Application number: 2025/91010	
What is the application for?:	Erection of flat over existing shop and form duo pitched roof over main building
Address of the site or building:	Your Convenience Store, 3-5, Moor End Lane, Dewsbury Moor, Dewsbury, WF13 4QE
Postcode:	WF13 4QE

User comments

**Proposed Rear Elevation**  
1 : 100

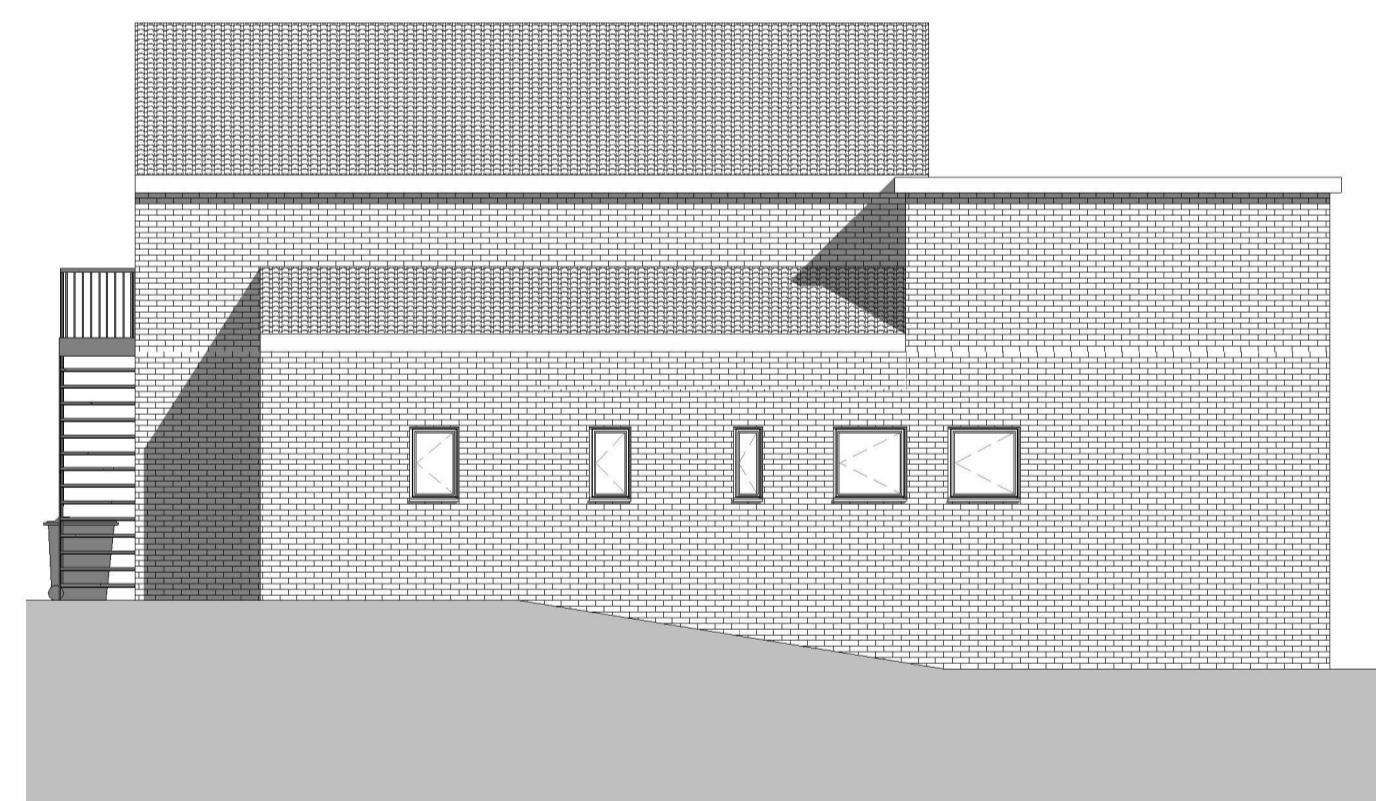
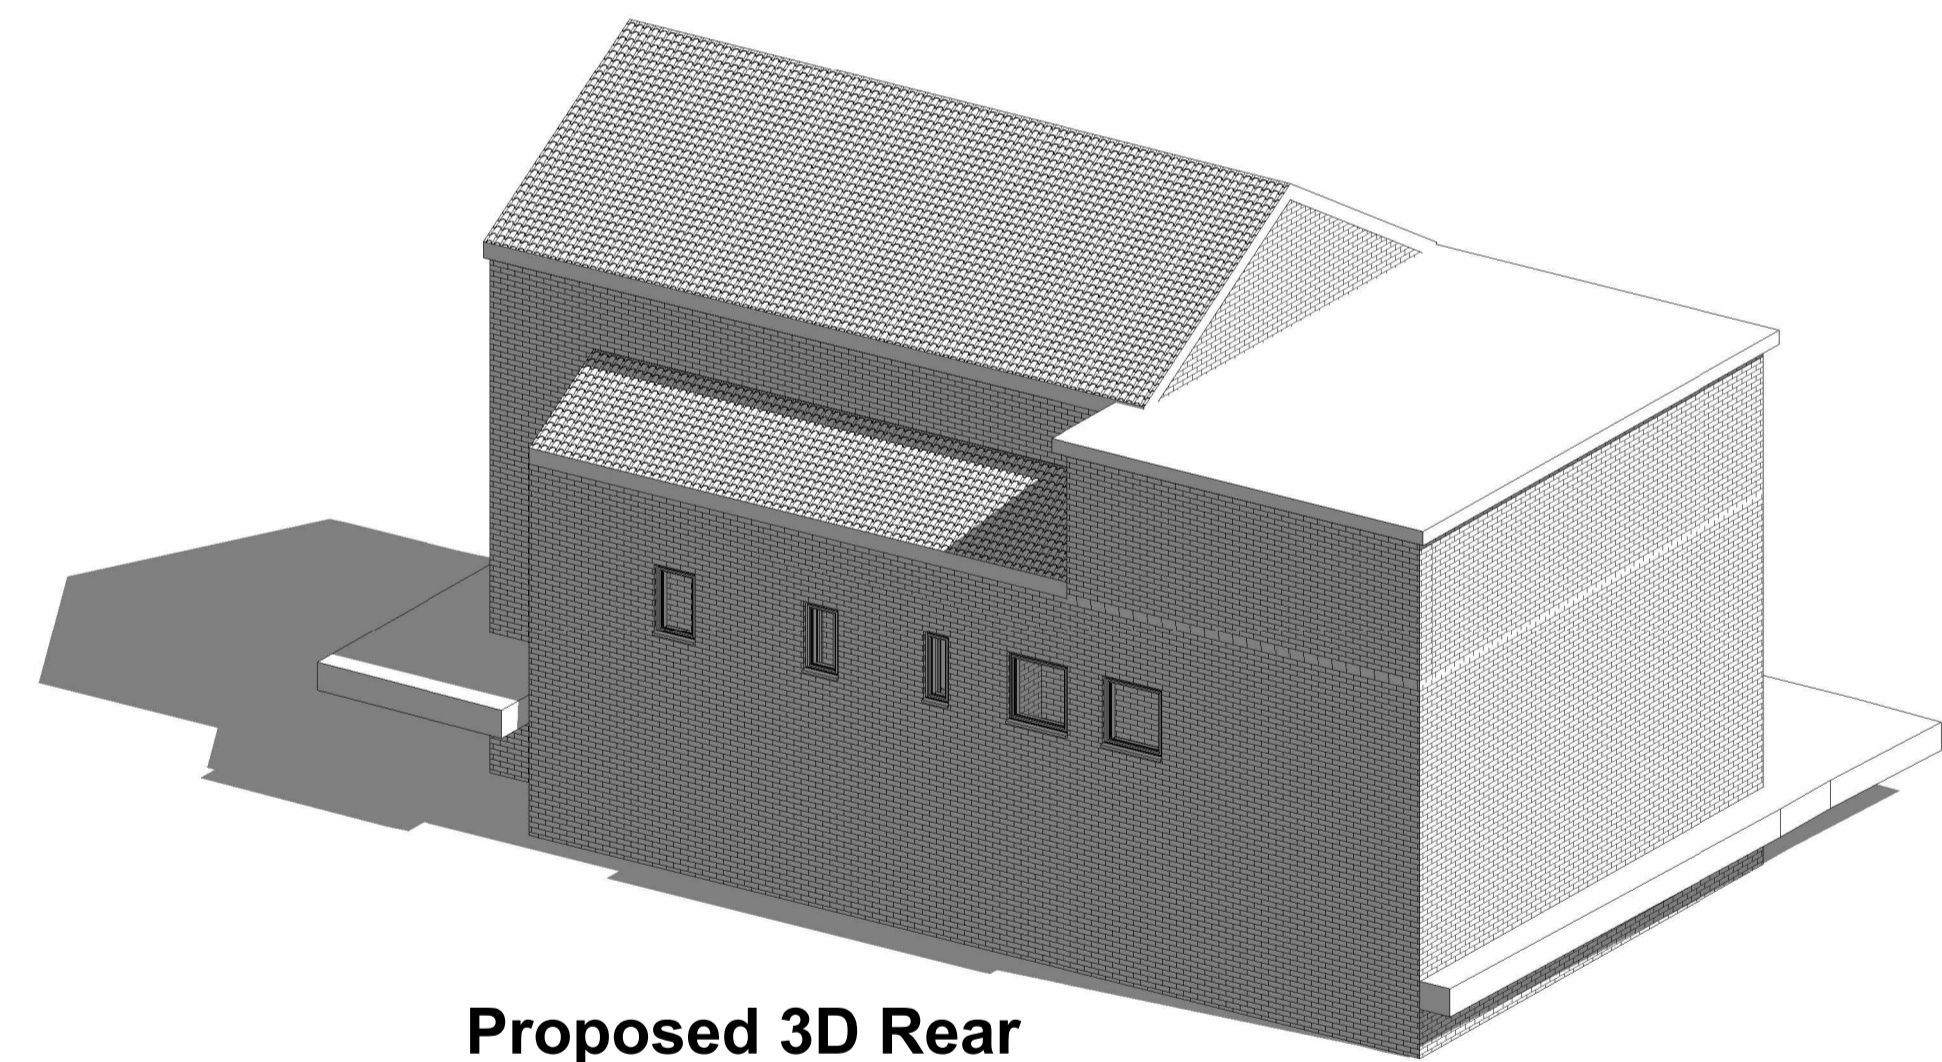
Type of comment: A general comment	
Do you wish your comments to be published on the website anonymously?	Yes
I have seen the plans and the fire escape/ access and windows at the rear will overlook my property. The new height of the building will block sunlight from my house
